Submission – I wish to lodge an objection to SSD-82639959, Precinct 75 Mixed Use Development.

SSD-82639959 seeks to amend/replace DA2021/0799 and DA2021/0800 to:

1 SOUTH-WEST - MARY ST
SCALE 1 : 250

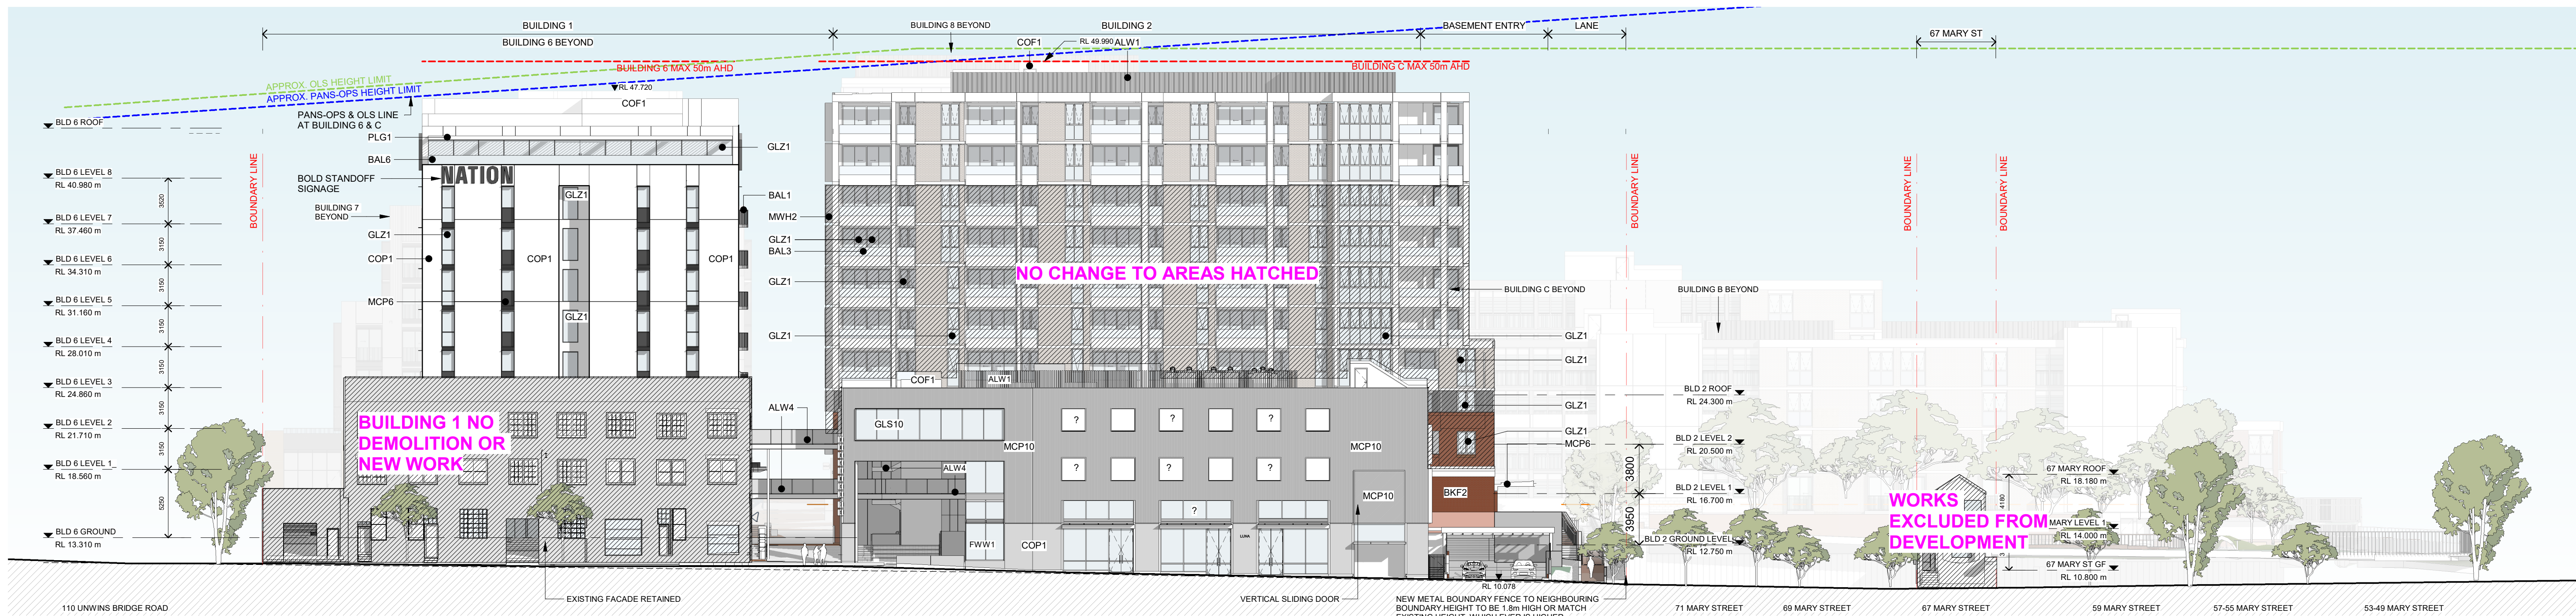
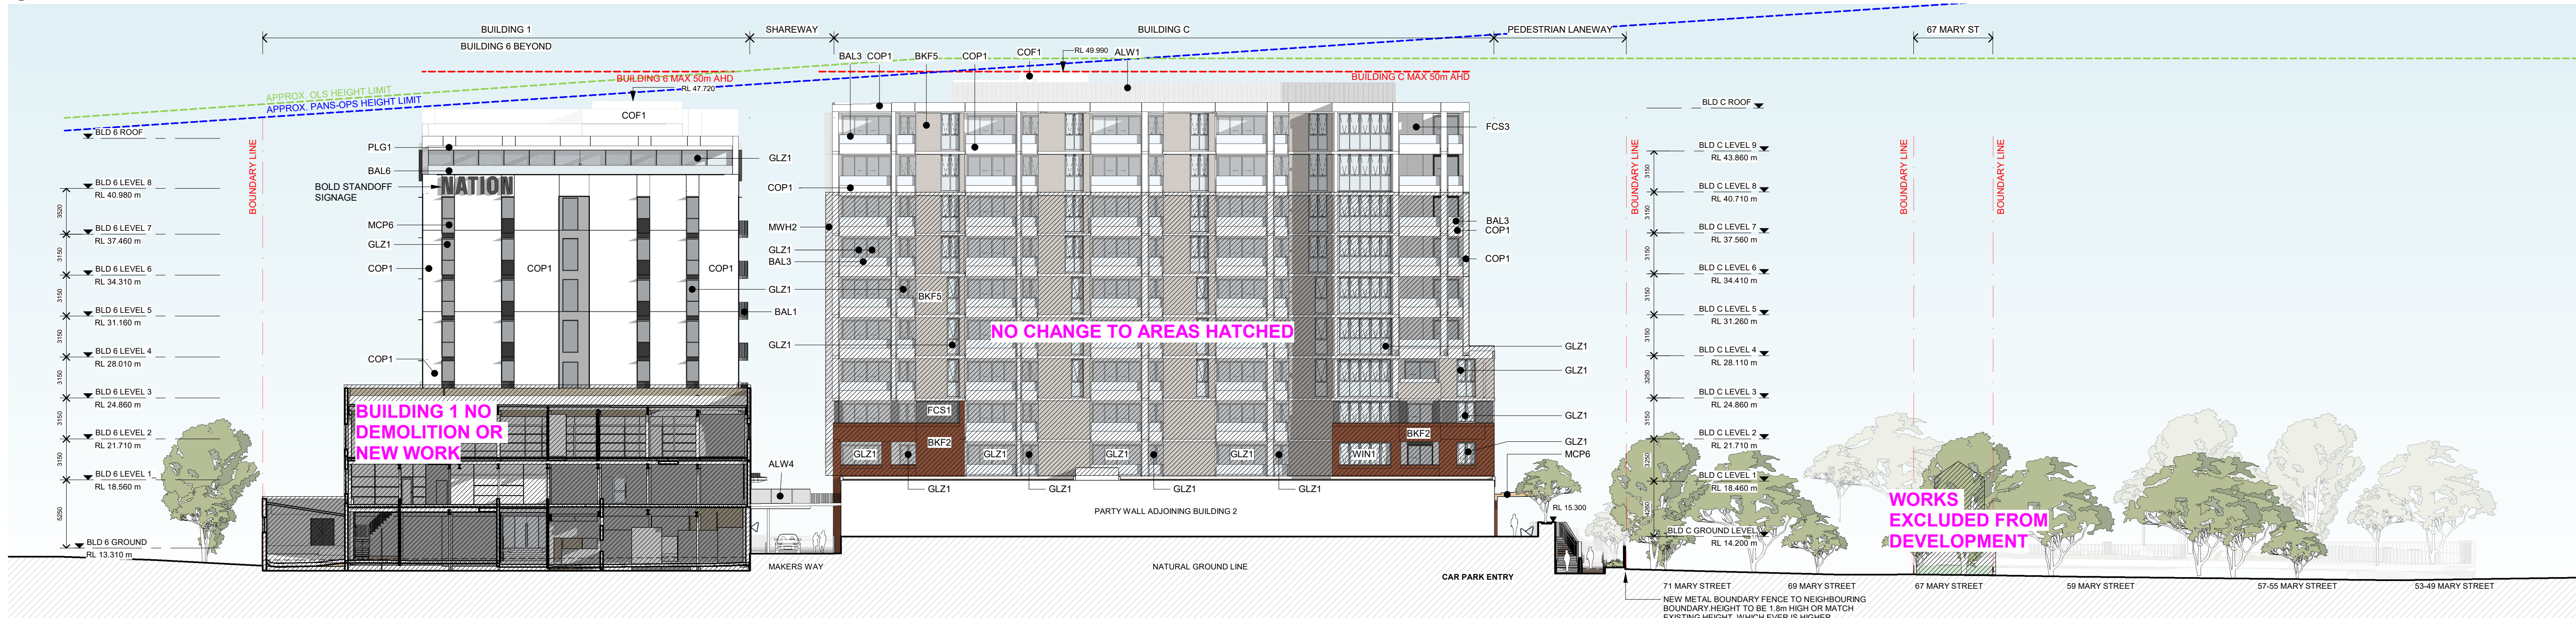
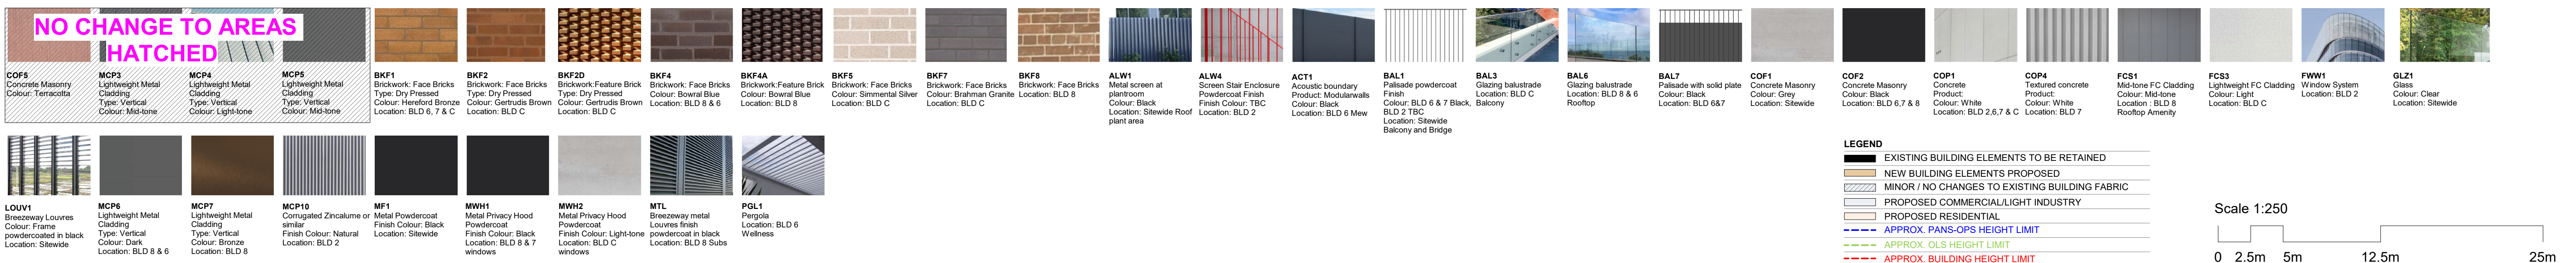
13. Under DA2021/0800, the section of Building 1 on Mary Street had its windows removed, the Land & Environment Court in Annexure B requires, 'the existing ground floor windows within Building 1 on the boundary with the Unwins Bridge Road properties are to be replaced with fire rated frosted glazing'. The notation was been added to the drawing.
- Under SSD-82639959 on this section of Building 1, the windows are being retained and there is a notation added to the drawing 'Building 1 No Demolition or rework'. **This is incorrect**, Annexure B still requires the ground floor windows on the boundary to be replaced with fire rated frosted glazing. Refer Figures 12 & 13 below
